From: Sue Howell
Sent: 09 August 2017 16:12
To: Planning.Responses
Cc: Simon Davis
Subject: RE: Planning Consultation on: Y/40/17/OUT

Comments from Greenspace

APPLICATION Y/40/17/OUT

Description of Works: Outline application with some matters reserved (access only) - erection of 34No. dwellings with access from Hoe Lane, Flansham. This application affects the setting of a Listed Building. This application is a Departure from the Development Plan.

Appendix A Architects Layout GA

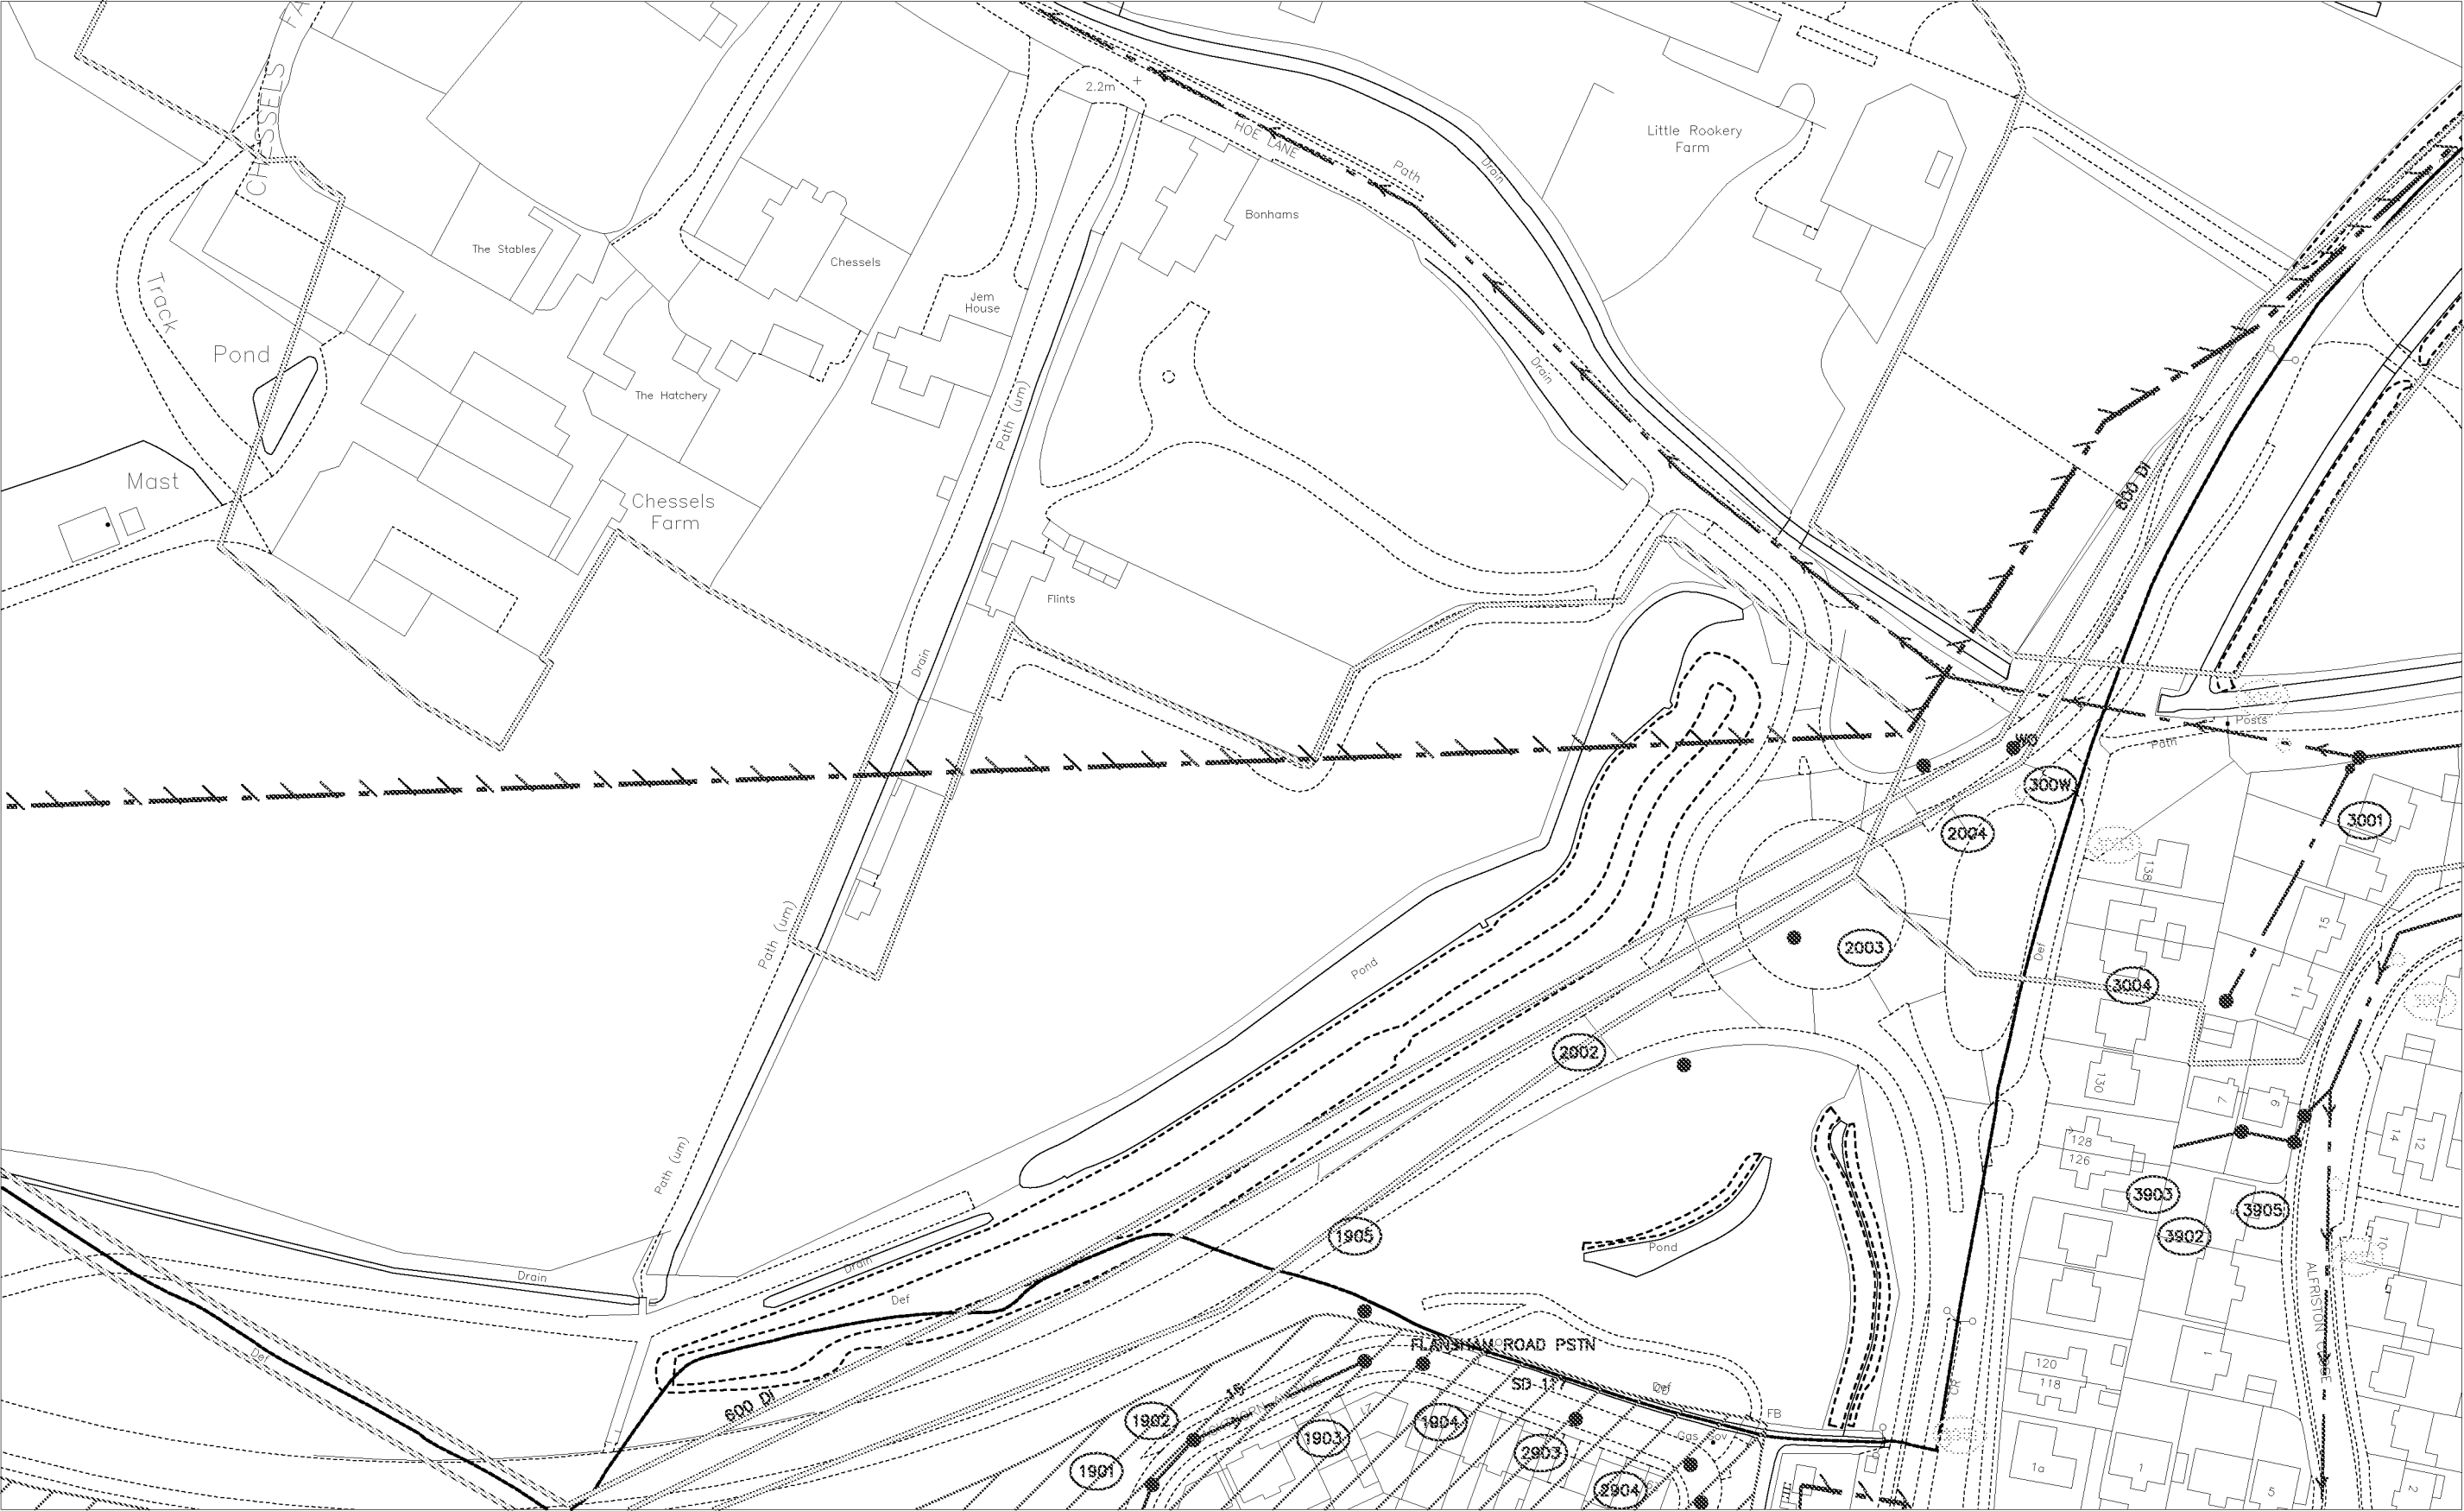
The proposed indicative layout shows two small areas of open space which would appear to be pretty unusable with no connectivity to the wider surrounds and no play consideration indicated. There does not appear to have been any consideration of the existing significant trees and to the incorporation of these into any open space areas. The existing trees have been indicated as proposed to be within the garden confines of several of the proposed houses which would have the potential to be problematic and not offer long-term protection going forward. The whole nature of this proposed site would be dramatically changed with a layout that appears to be hugely over developed.

I would recommend that the Public Open Spaces and their connection with the proposed development are reconsidered and that all of the above points are agreed or conditioned with any decision.
